Re: Objection to MP08_0244 MOD 1 Modification Request for Mixed Used Development at 23-37 Lindfield Avenue and 11 Havilah Lane, Lindfield

ELEVATIONS

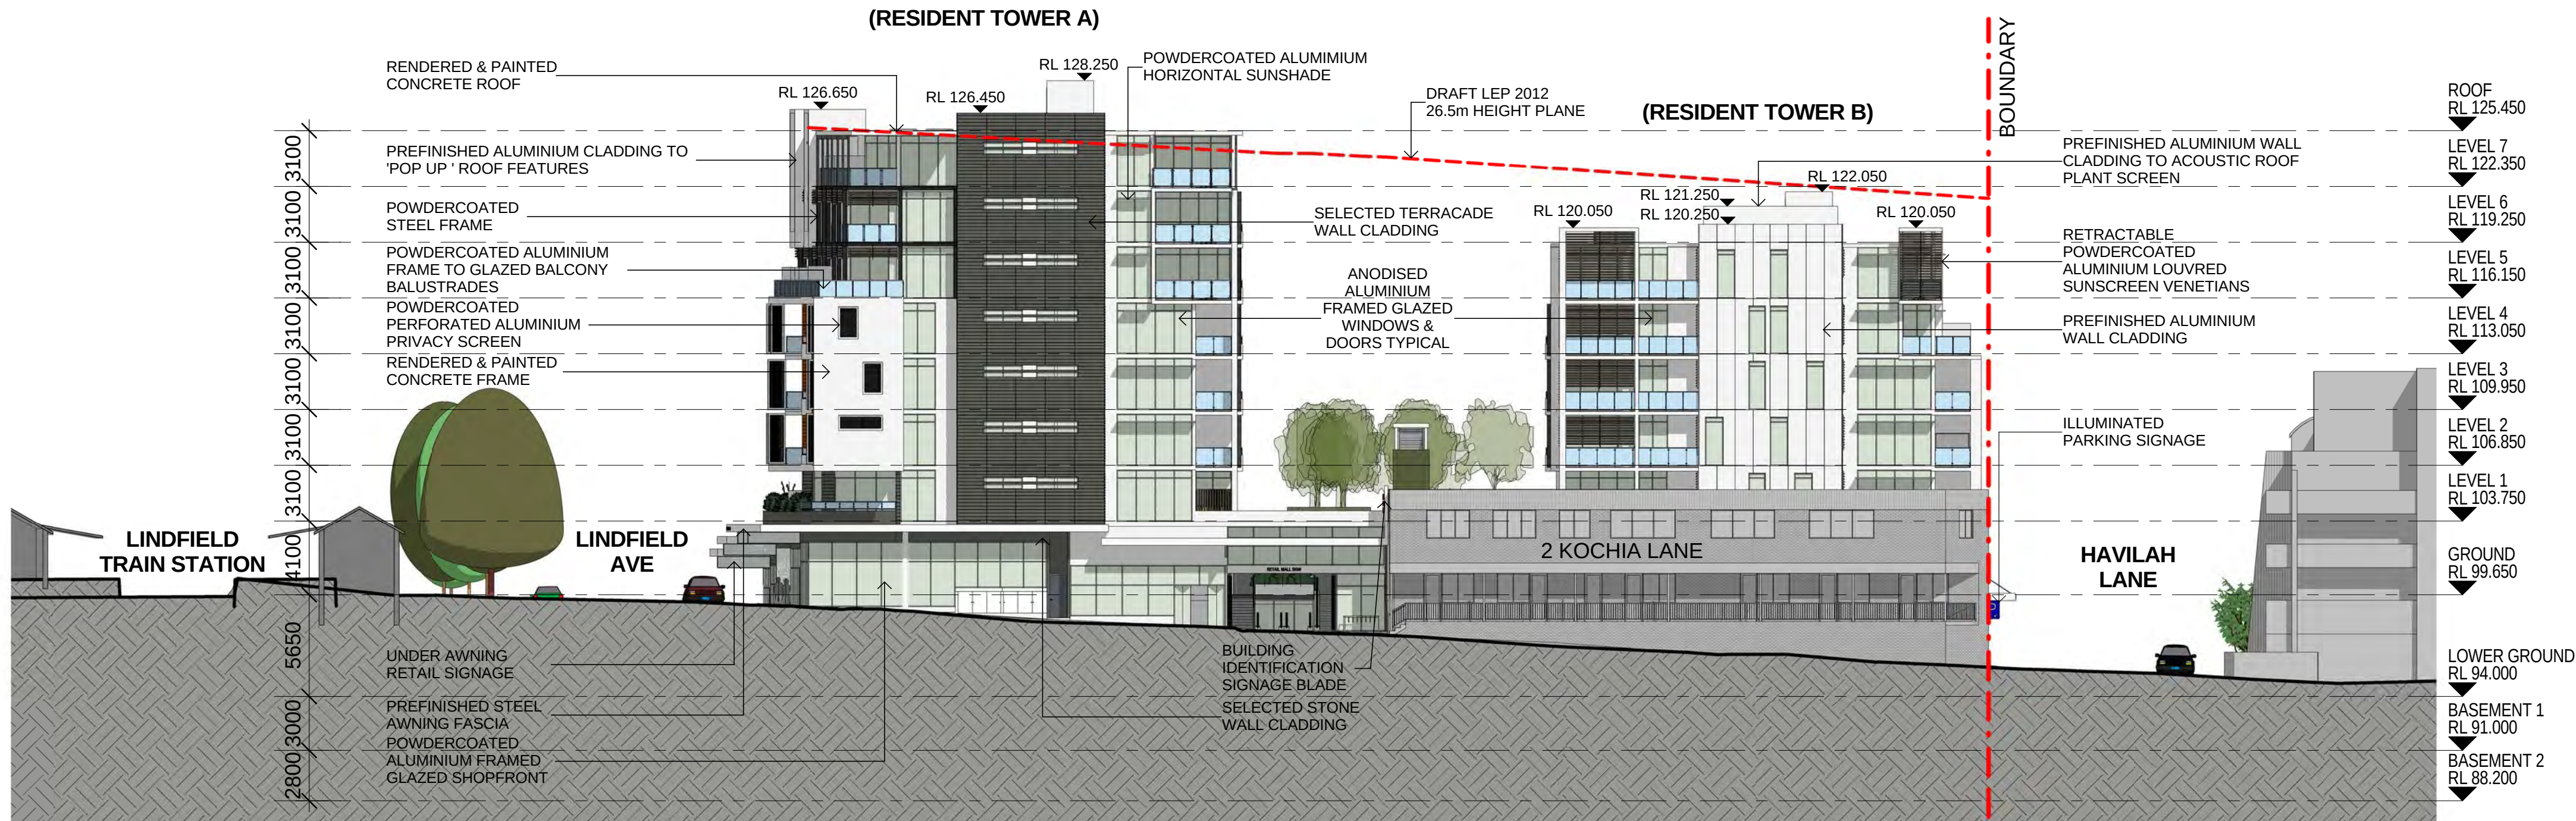
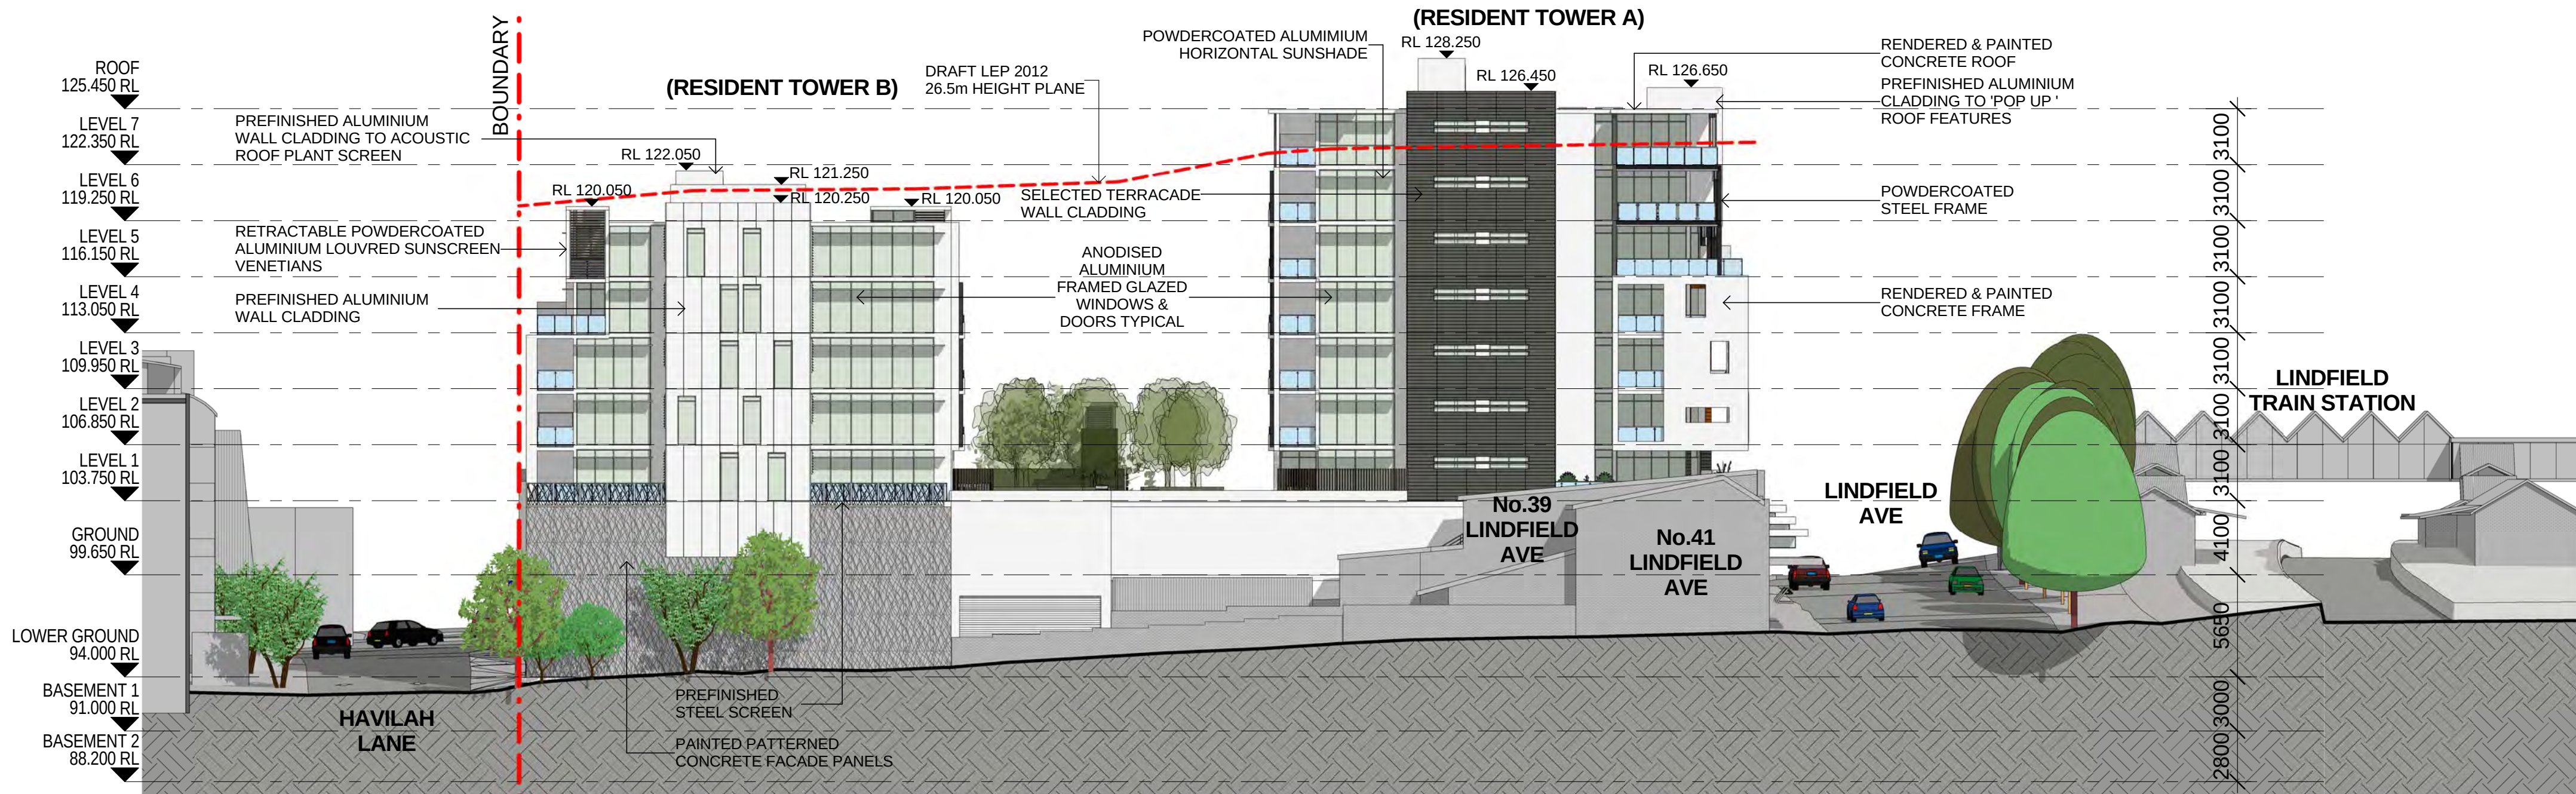
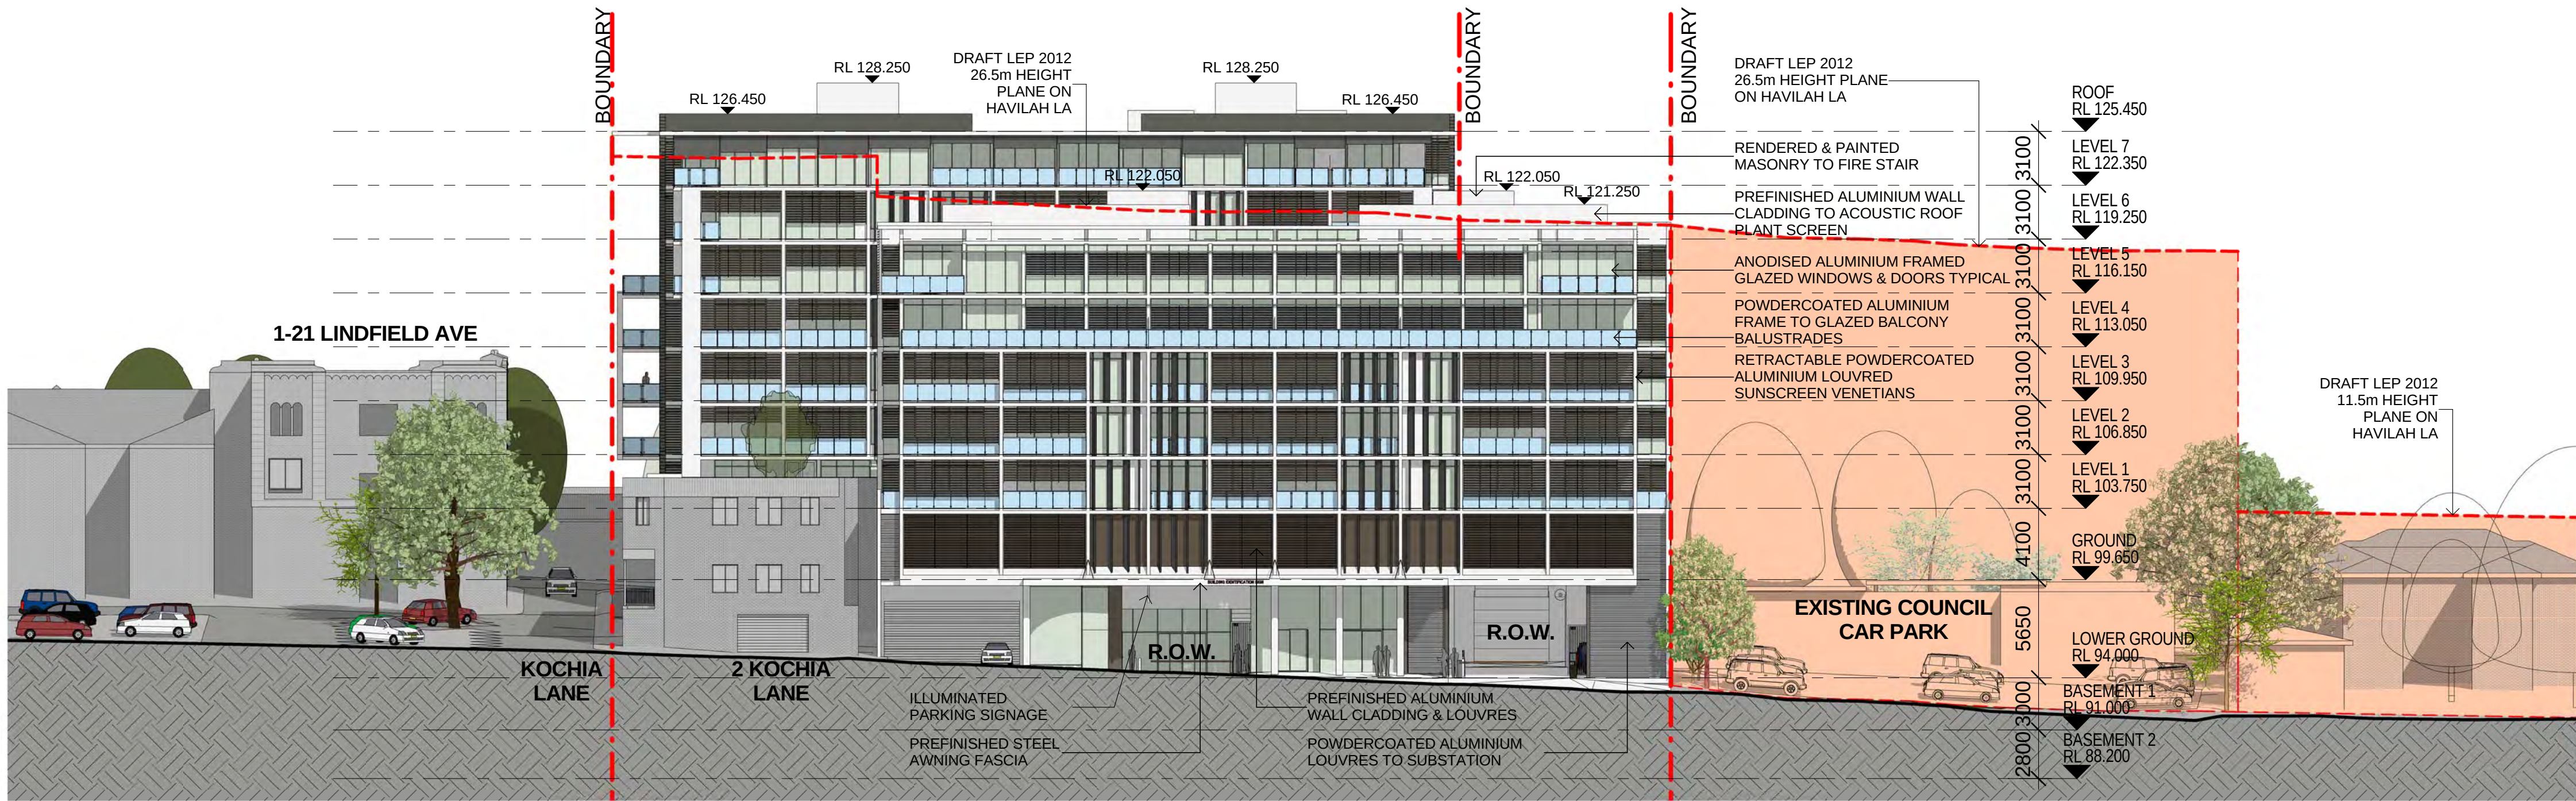
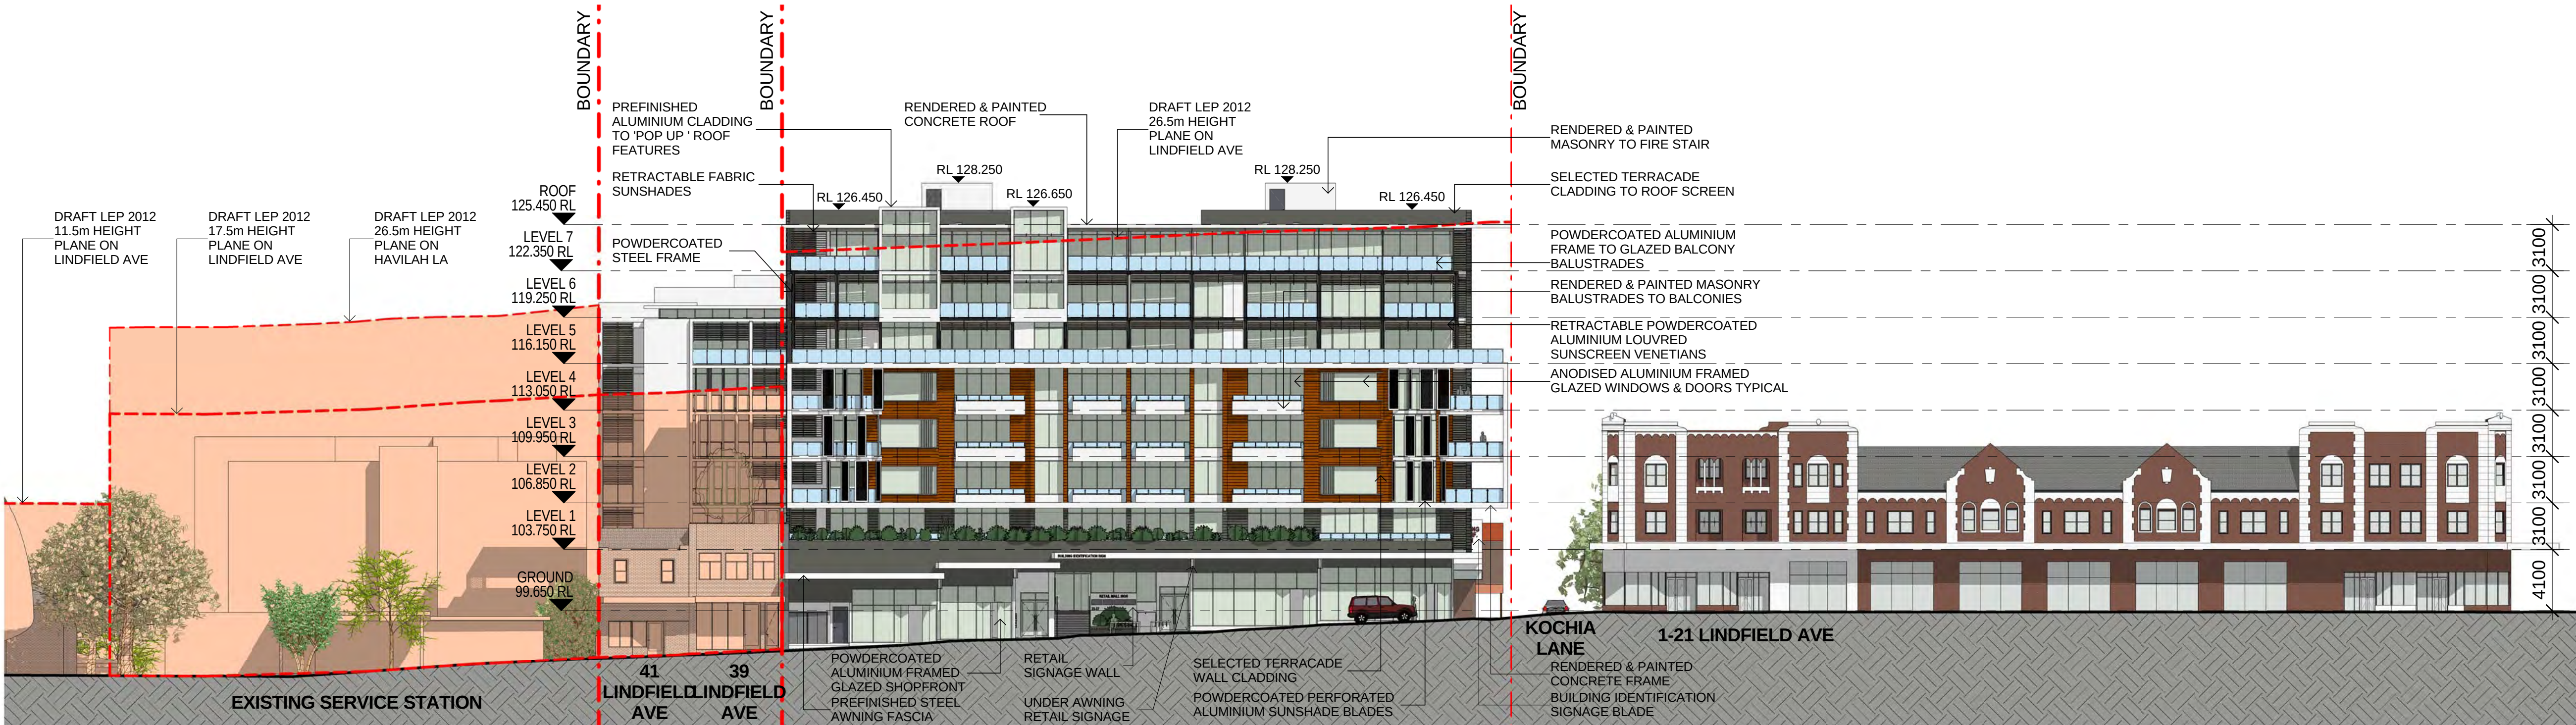
- The increase of an additional storey to both buildings: 8 storeys on Lindfield Avenue and 7 storeys on Havilah Lane creates excessive height and bulk and is out of character with the surrounding buildings, including the heritage listed adjacent building on Lindfield Avenue

- The additional storey (combined with less set back than the approved design) on Havilah Lane now creates privacy concerns for over 40 apartments in the adjacent 8 Havilah Lane, 8 Kochia Lane and 2-8 Millray Street residences
